Submission ID: 4058

Without wishing to protract the seeming impasse on parking that appears to exist between the Applicant and myself, I would be grateful to the Applicant (and the ExA if necessary) for an explanation as to why the Car Parking figures quoted by the Applicant at 1.5 Car Park - Design and Sizing (Document - Written Submissions from ISH3) appear to me to contradict the car parking numbers included in Schedule 1 (Part 1 Numbered Works) of the Draft DCO.

DRAWING TITLE:
NORTHERN PARK AND RIDE
PROPOSED PARAMETER PLAN

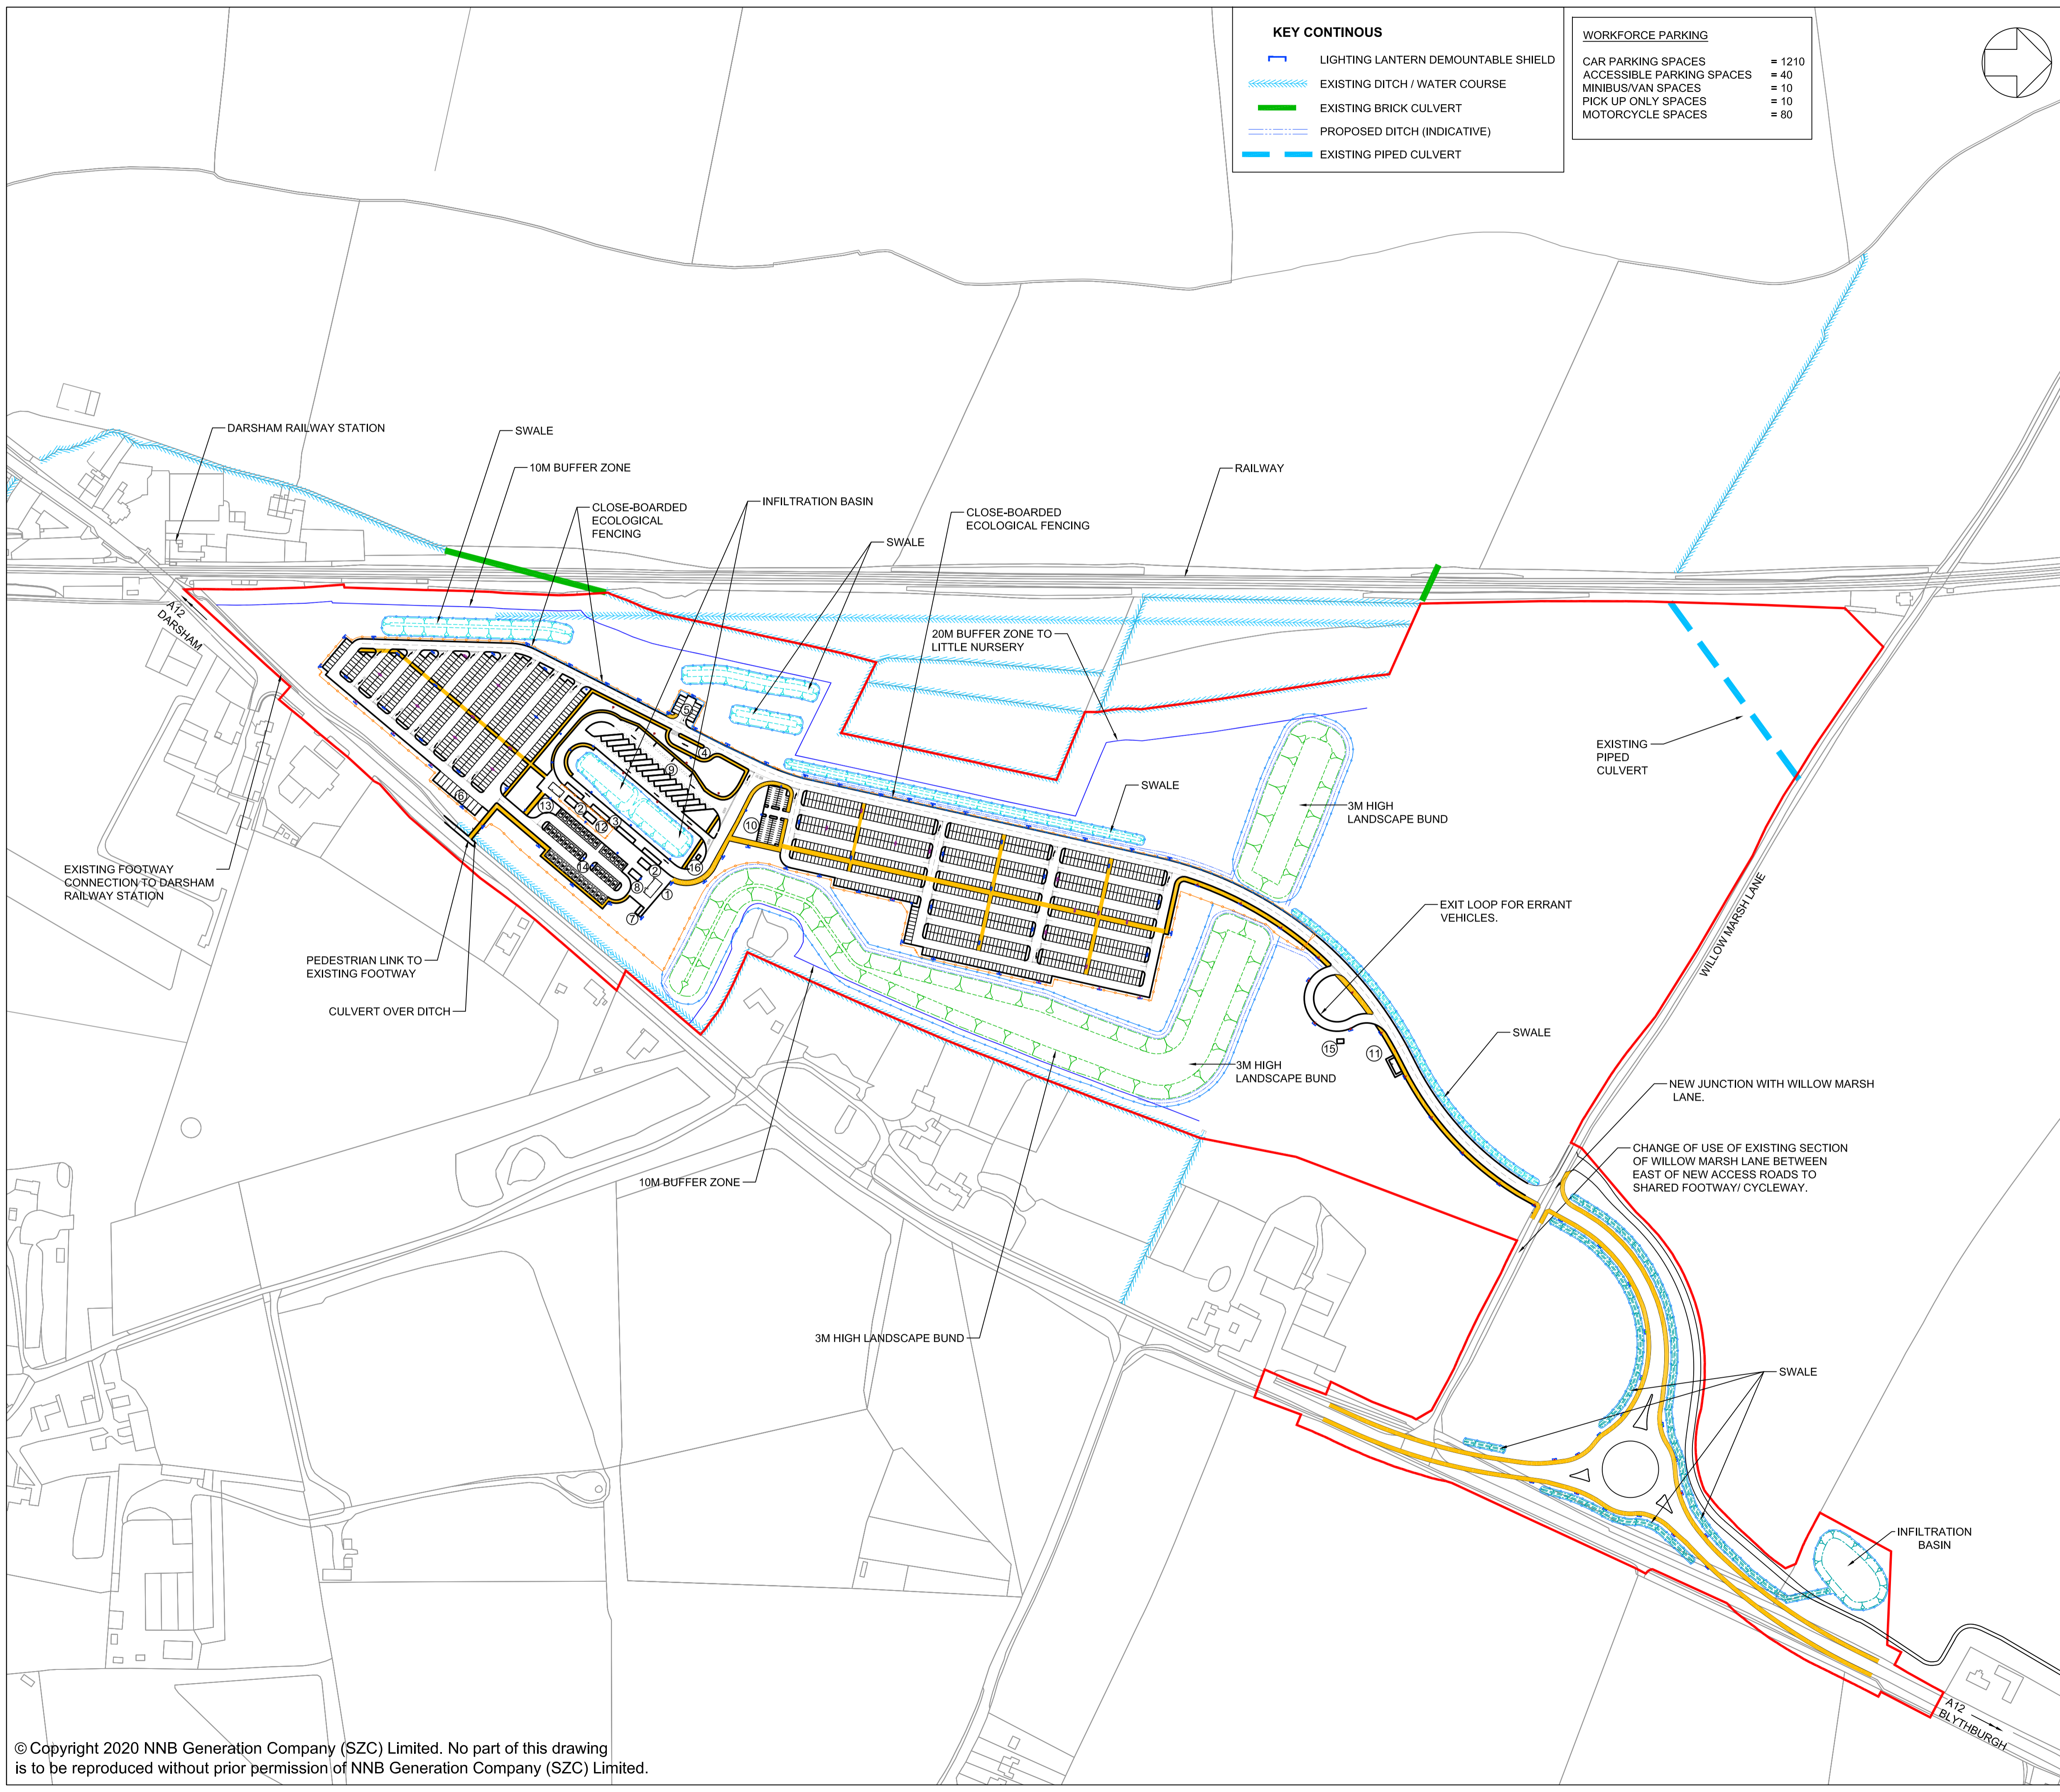
Specifically at (r) approximately 1,370 permanent parking spaces, at (x) approximately 1,000 parking spaces, at (z) MDS Park and Ride approximately 600 associated car parking spaces, TOTAL > 2970 spaces as opposed to the Applicants quoted 1,000.

Moreover at Para 1.5.2, bullet one of 1.5 Car Park - Design and Sizing (Document - Written Submissions from ISH3) the Applicant notes a proposal to provide a 1,000 space car park and asserts only 12% of the construction workforce will be able to park at the MDS.

Surely this is misleading insofar as, allowing for shift changes a new portion of the construction workforce will also utilise the 1,000 car parking spaces and increase the %age from 12%.
